DECISION DELEGATED TO HEAD OF PLANNING

Application No: H14-0889-25 **Applicant:** Mr J Carter
Proposal: Conversion of agricultural barn to residential dwelling
Location: Nunnerley House Farm Leaveslake Drove West Pinchbeck
Terminal Date: 12th December 2025

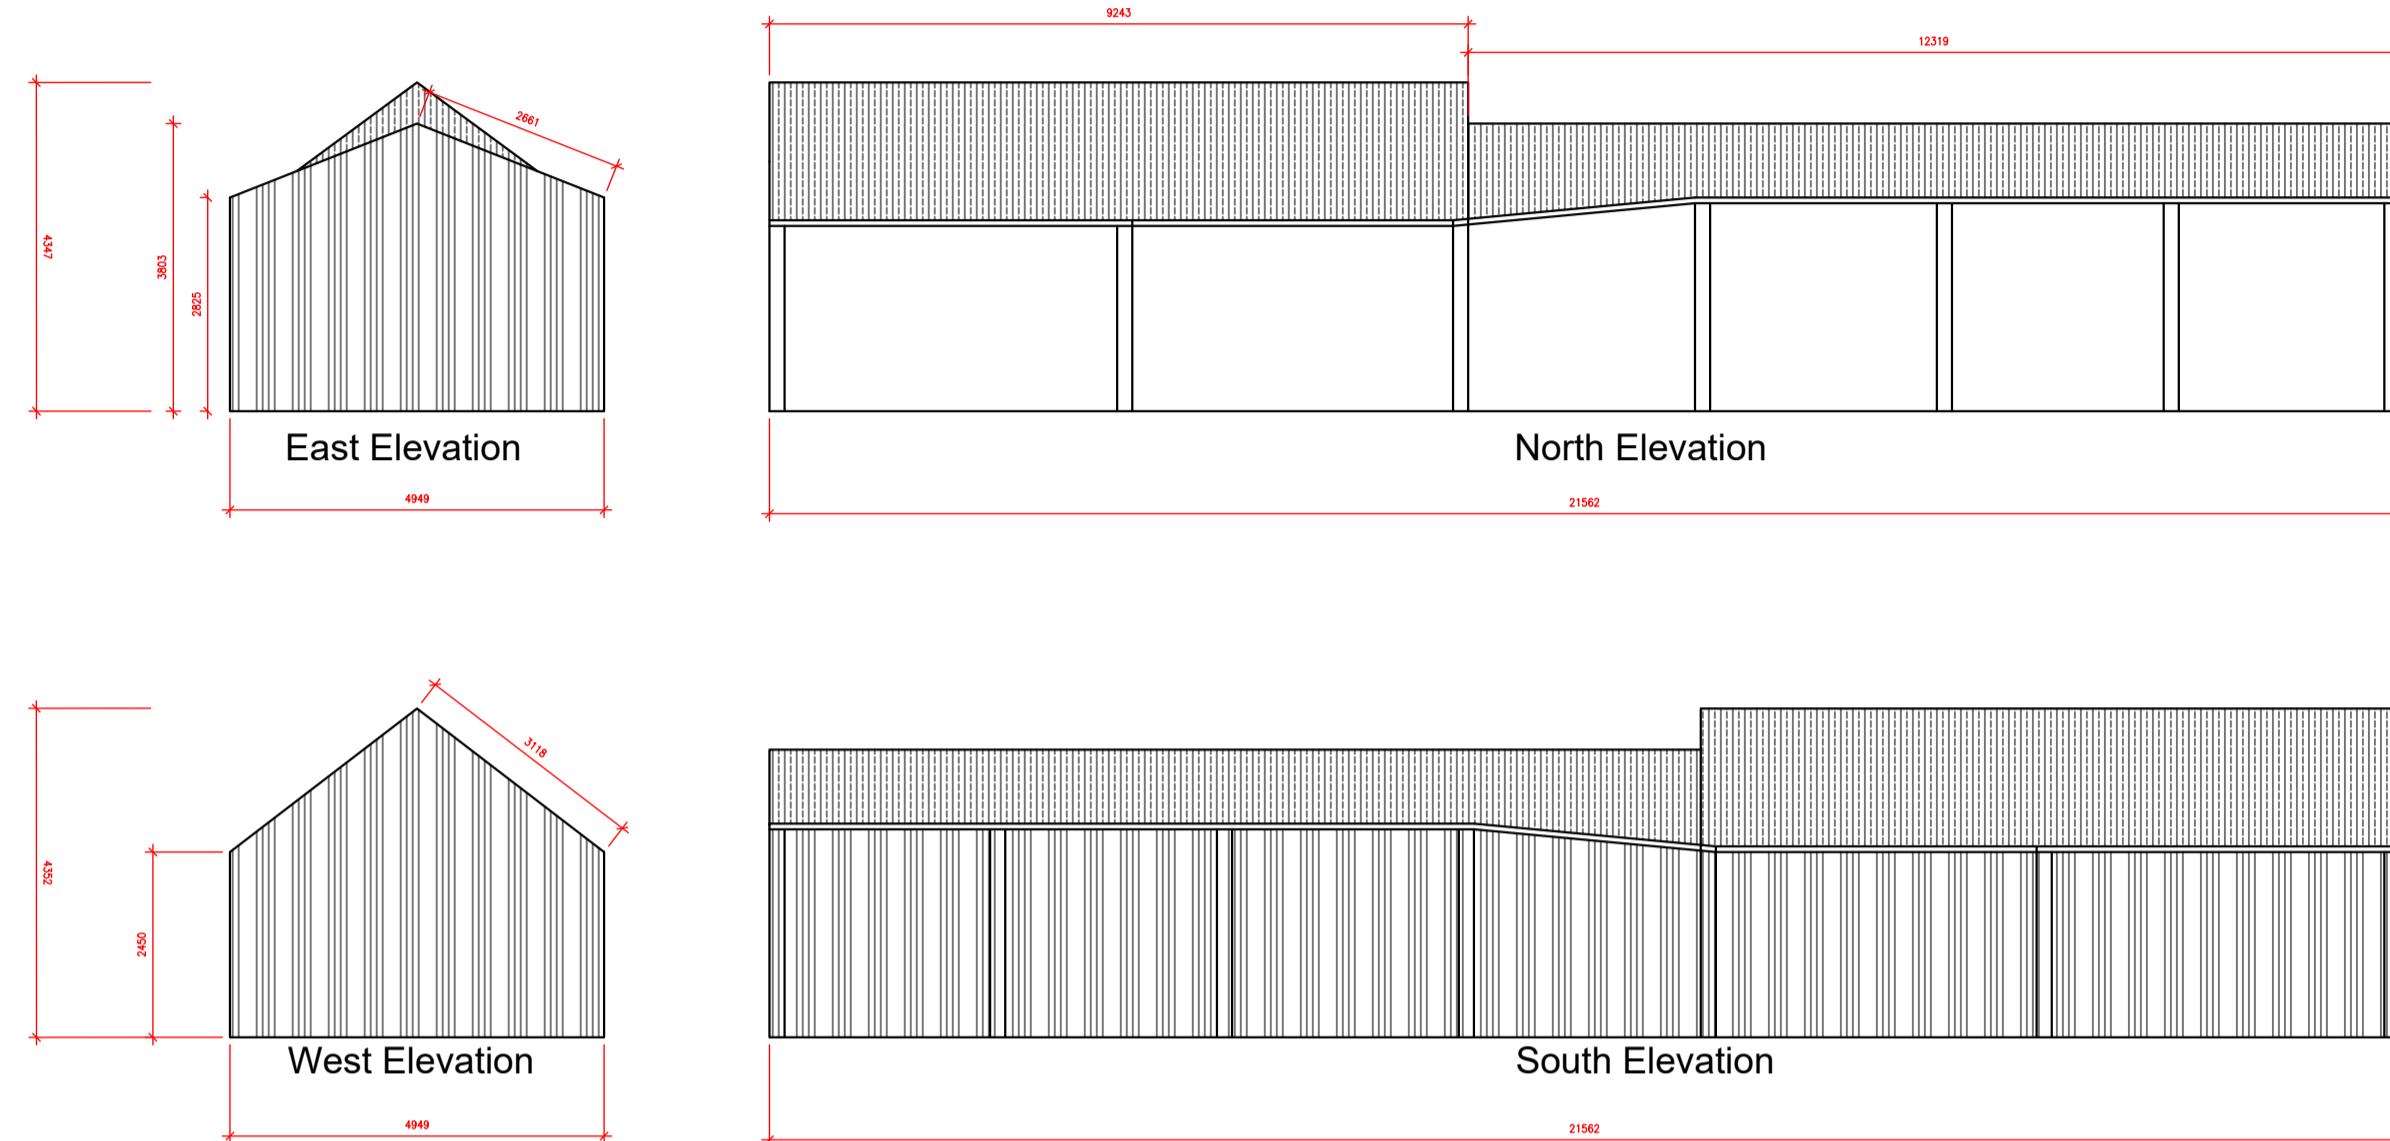
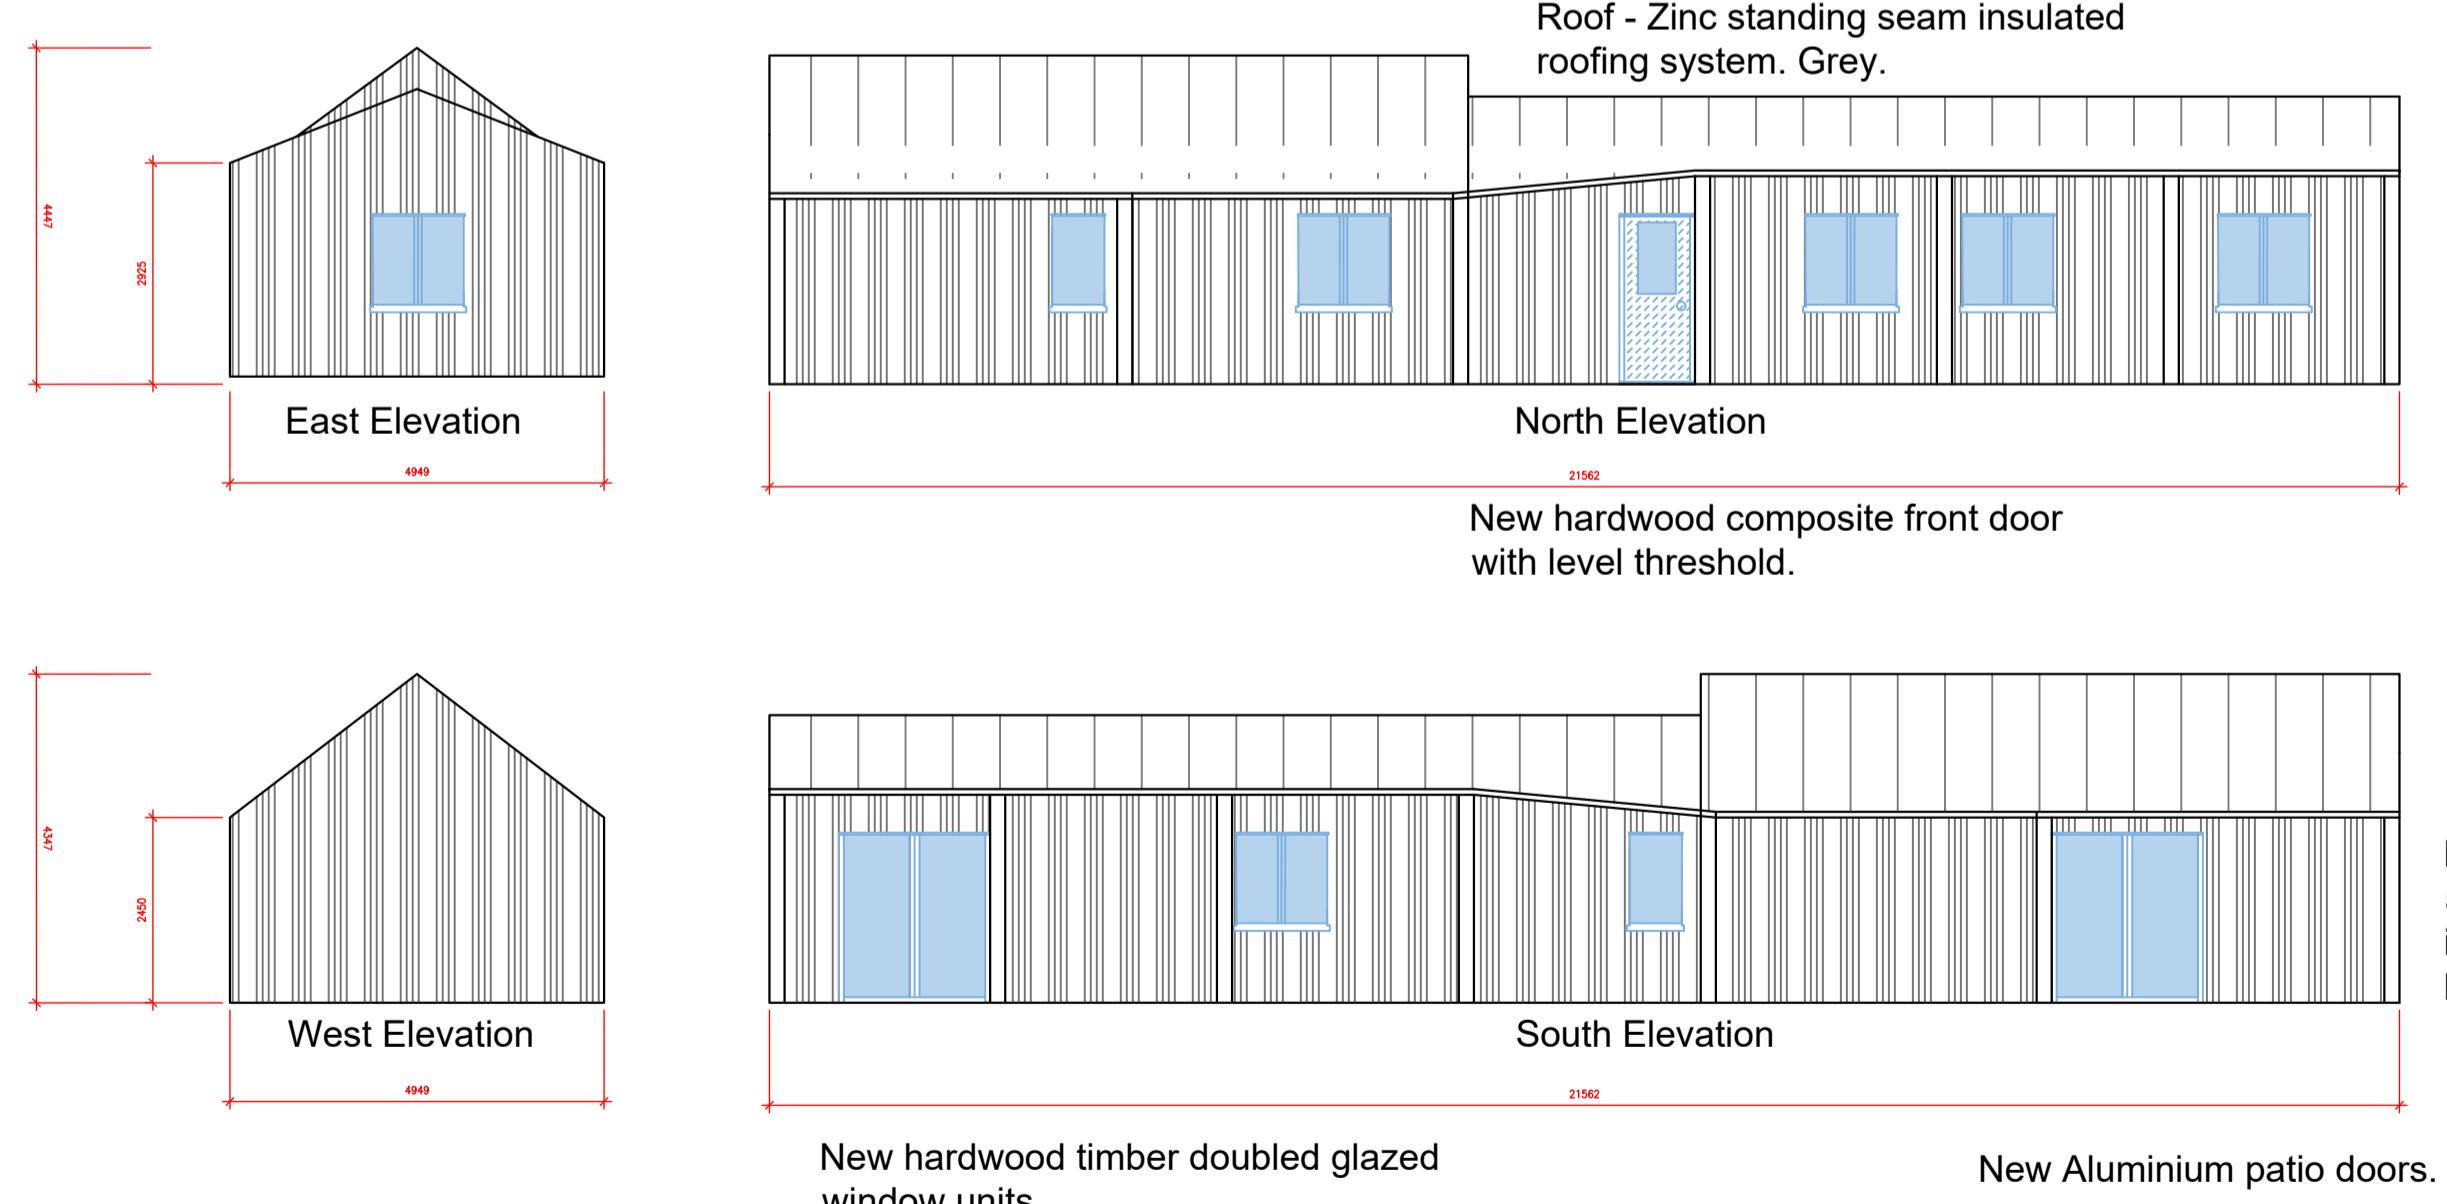
In this case, no extensions are proposed, and the building would not be partially demolished. To facilitate the conversion, the proposal seeks to install external timber cladding and to install a zinc standing seam roof. Various windows and doors are proposed on the elevations of the building.

Whilst the report summarises that the building is suitable for a Class Q conversion, the LPA has concerns with the conclusions of the report. Class Q allows for the installation of new walls and roofs, which are proposed in this case. However, the building structure should be of a suitable condition to allow for conversion, rather than a re-build. The report sets out that the posts can be 'reused' and that some of the posts and vertical timbers are rotten. The full condition of the timber within the structure has not been through a comprehensive appraisal. As such, it is unclear how much of the existing structure is rotten or damaged and subsequently, the extent of the existing fabric of the building that would be retained or replaced. Given the condition of external elements of the building, which at least in some places appear to be rotten, damaged, or missing, it is probable that large areas will require replacement or significant repair if not replaced in their entirety.

Notwithstanding the submitted structural report, it is considered that significant building works would be required to enable to re-use of the building for residential use. These would include a new roof, new external walls on all elevations, and potentially additional structural elements, as well as other works. Overall, the extent of the works required to facilitate the proposed residential use of the building goes beyond what could reasonably be described as a conversion, and would be so extensive as to comprise a rebuilding. As such, it is considered that the works required to facilitate the re-use of the building would exceed the limitations of part j.
